## 1806 Scott Street

Planning Rationale Addendum  
Zoning By-law Amendment + Site Plan Control  
September 5, 2023

Prepared for 2851944 Ontario Inc

1
A001
GROUND FLOOR SITE PLAN
1:100

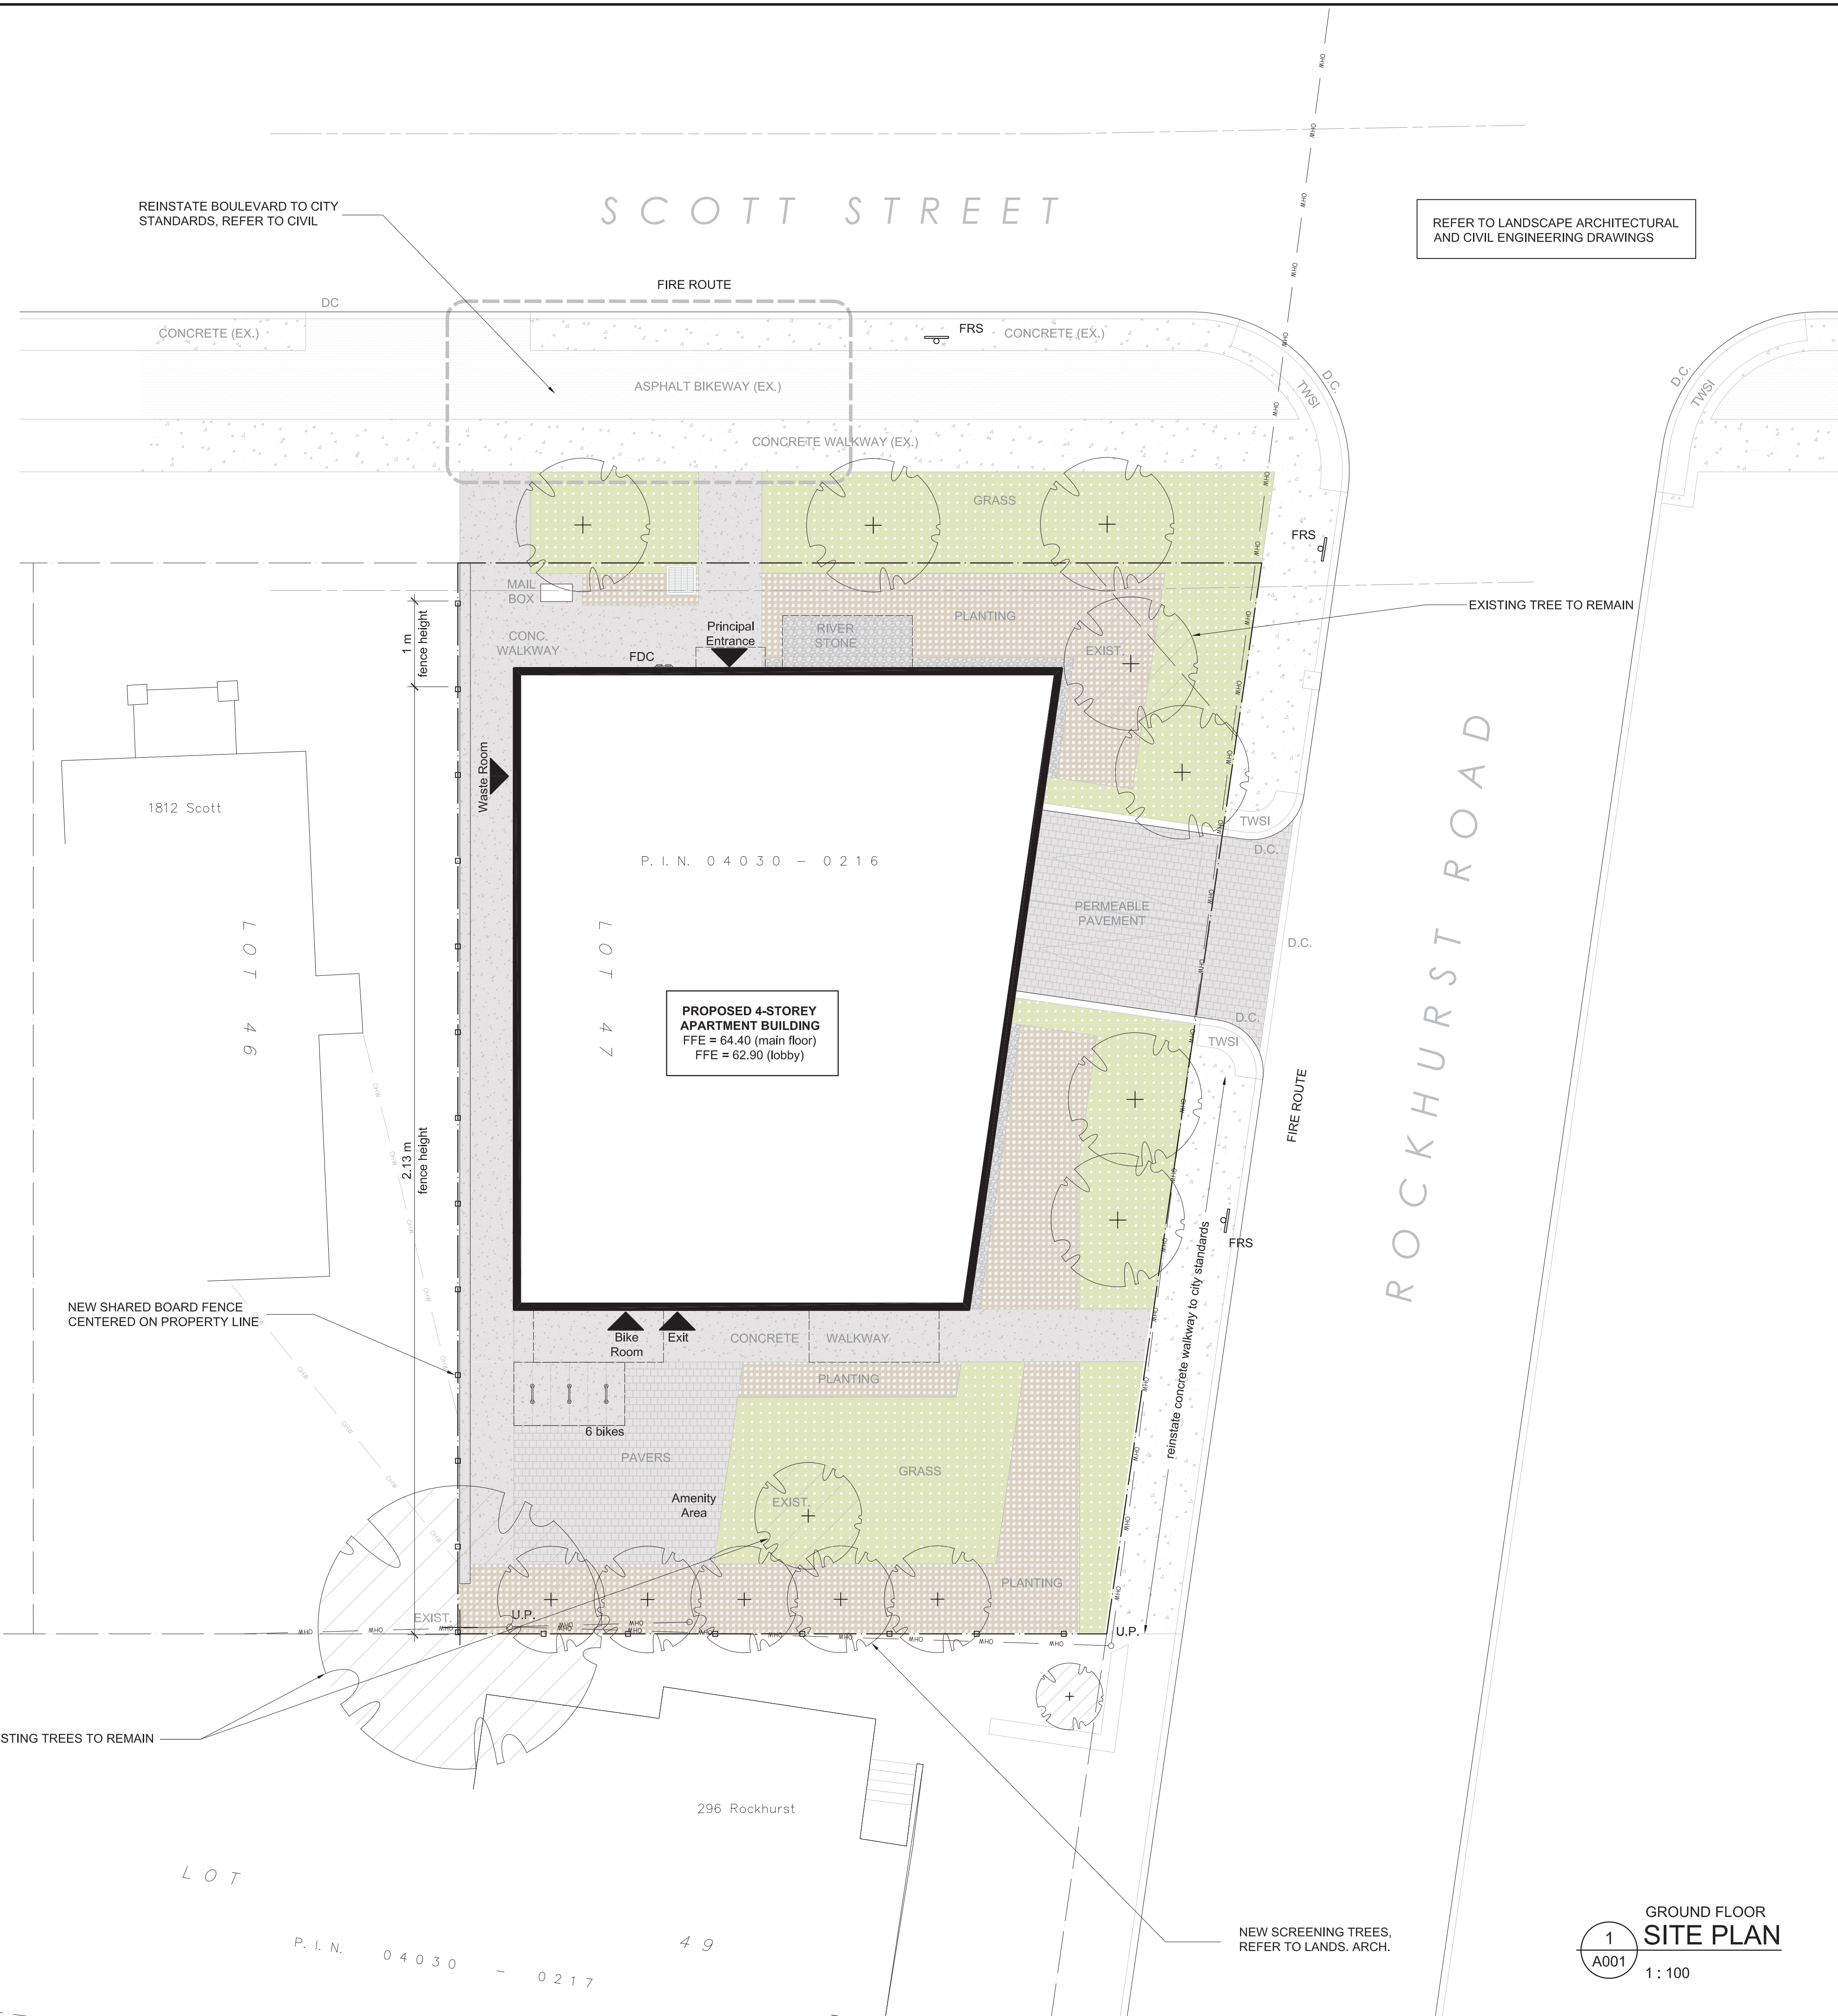
- / Increasing the rear yard setback from 7.5 to 9.23 metres to improve privacy of the adjacent existing residential dwelling to the south and mitigate the potential for overlook;
- / Replacement of the cedar hedge along the south property line with Pyramidal English Oak trees, which will provide increased privacy and screening between the proposed development and the existing residential dwelling to the south;

The ground floor entrances were redesigned to locate the front door to face Scott Street and the garbage room door facing the interior side yard to the west.

For improved safety and improved streetscape, the outdoor bicycle parking rack has been relocated to the rear yard.

Two (2) parking spaces are now proposed to remain in the same location as present, on Rockhurst Road slightly south of the intersection of Scott Street. The original application had these two spots further to the south in an area that is currently grass. As with Submission 1, the parking spaces on Scott Street are proposed to be removed. The parking configuration is confirmed as early as 2002 using aerial photography from GeoOttawa and appears to have been established some time between 1965 and 2002, as no curb cuts are visible in aerial photography from 1965, but parking is visible in 2002 aerial photography, shown below in Figure 2 and Figure 3. This demonstrates a long-standing, pre-existing condition related to front and corner yard parking on the subject site.

Pursuant to Section 57, corner sight triangles must be maintained at the intersection of Scott Street where it intersects with Rockhurst Road. Per comments received from Transportation department staff, a 5-metre x 5-metre corner site triangle is required and provided. This is shown on the site plan.

1 EAST ELEVATION
A200 1:150

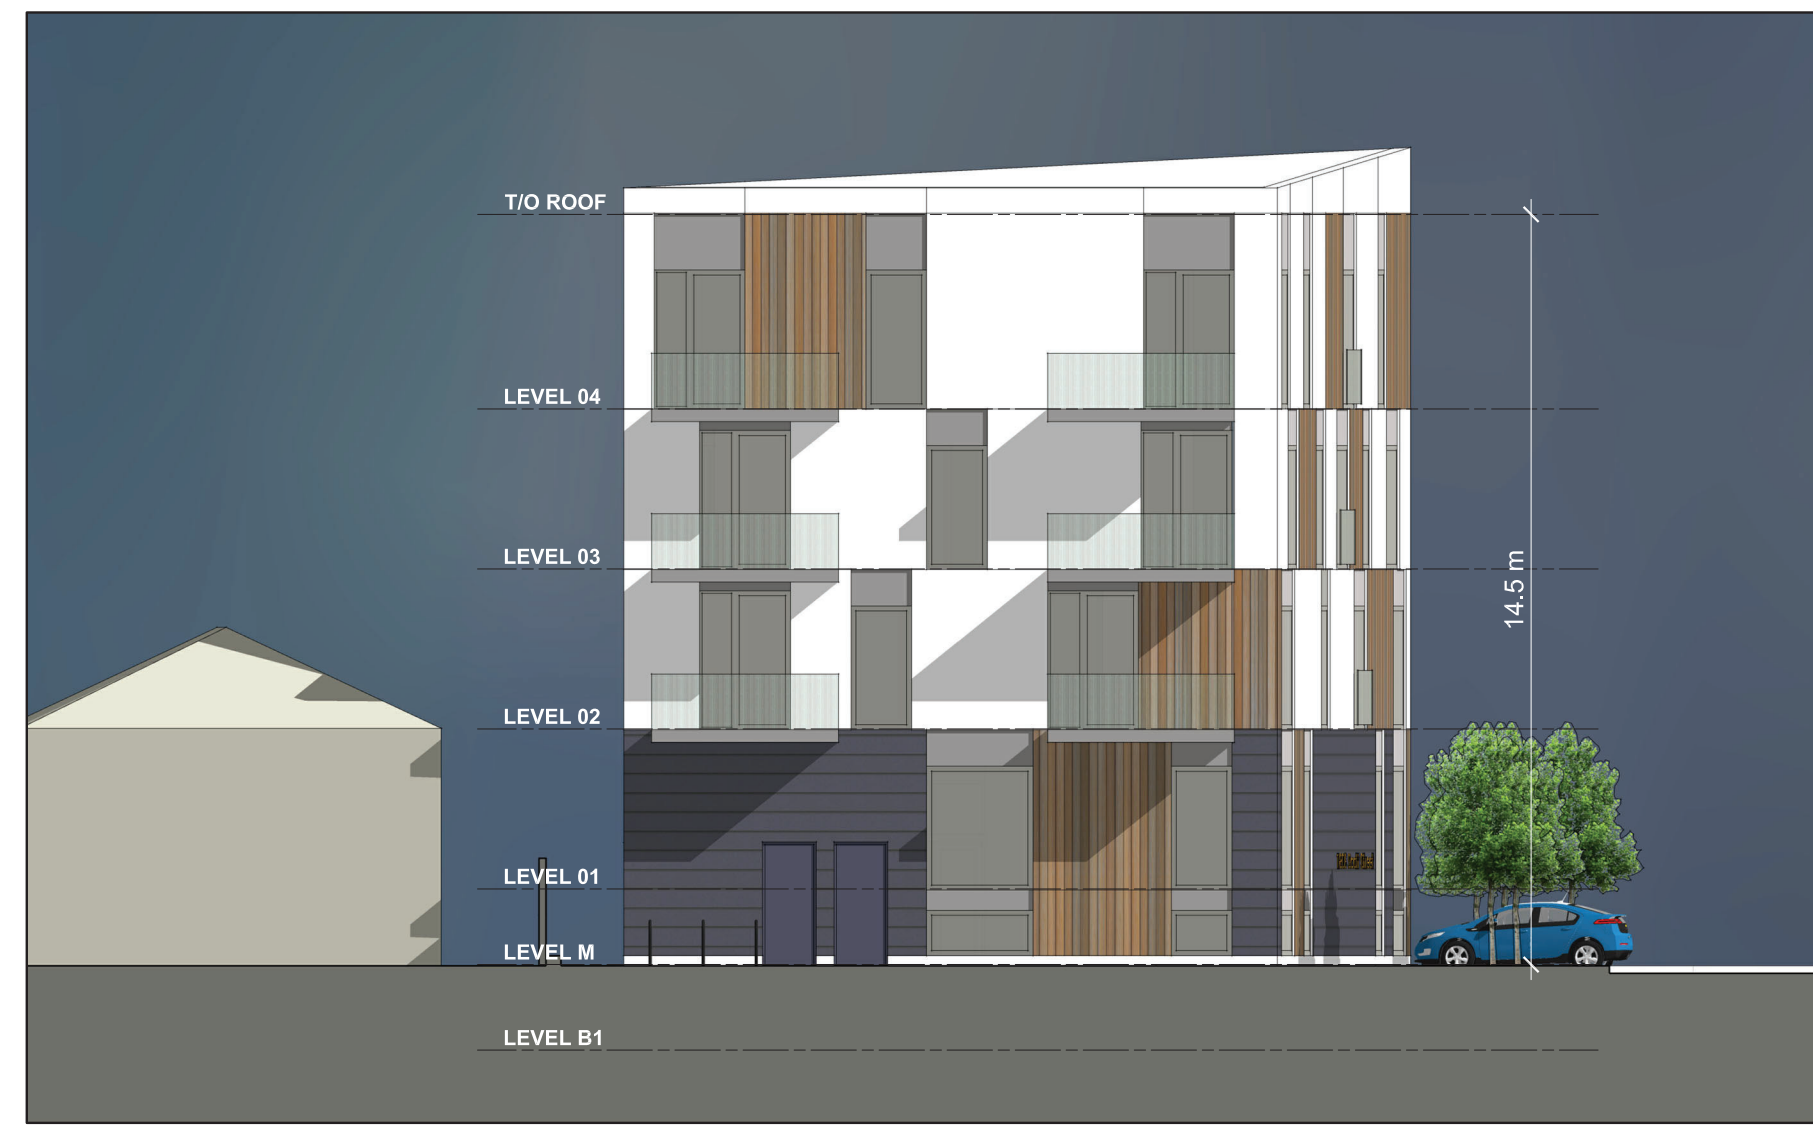
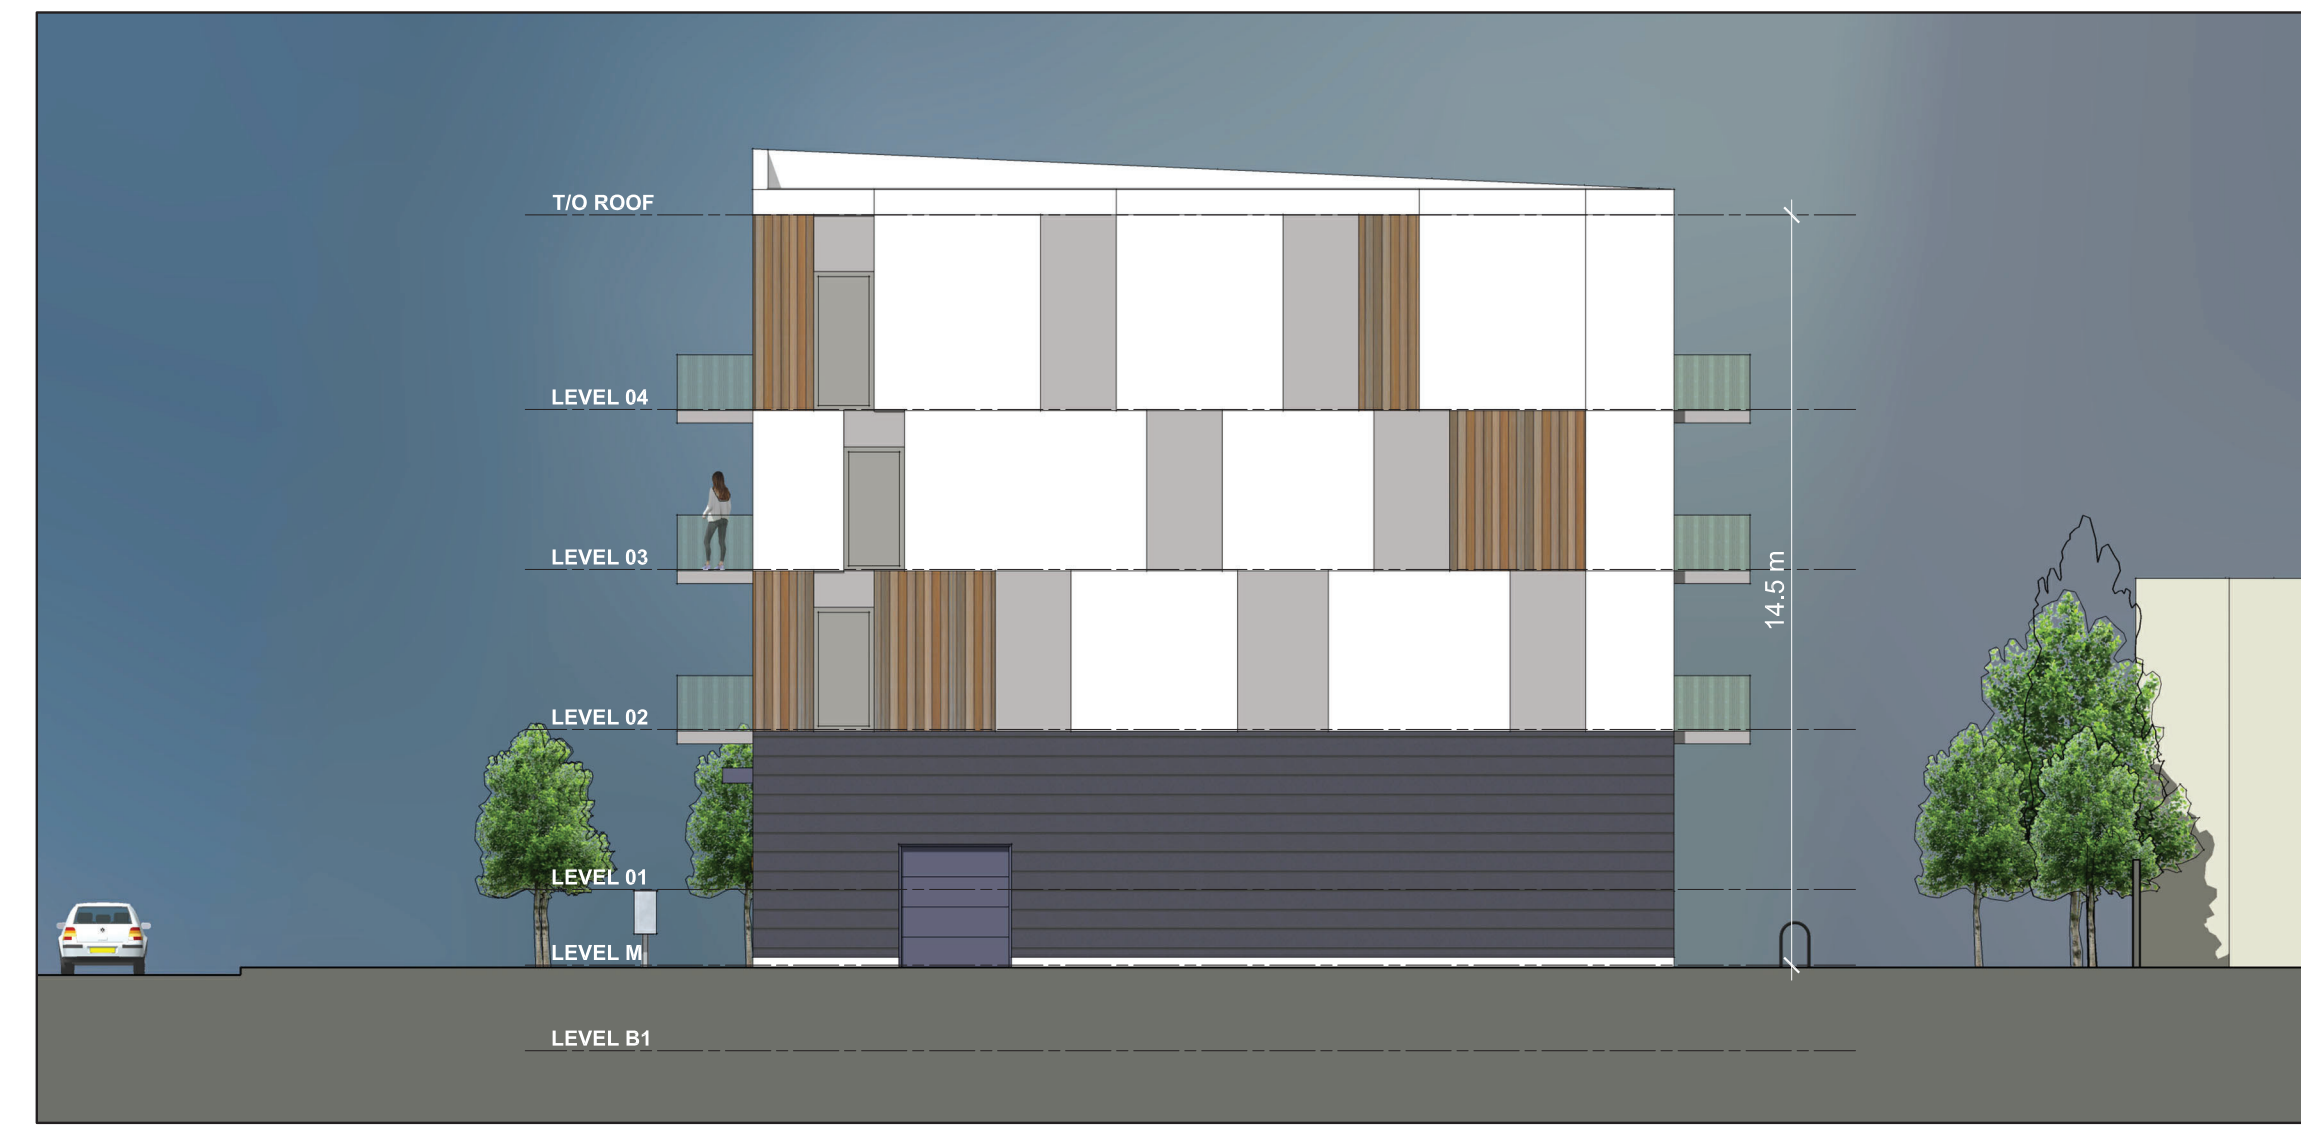
In response to feedback from the public, the building design has been adjusted to introduce additional colours to the ground floor, including a charcoal horizontal accent siding, shown below in Figure 7 and Figure 8. The charcoal siding emphasizes the ground floor and provides a transition in materials to add visual interest and break up the massing of the building.
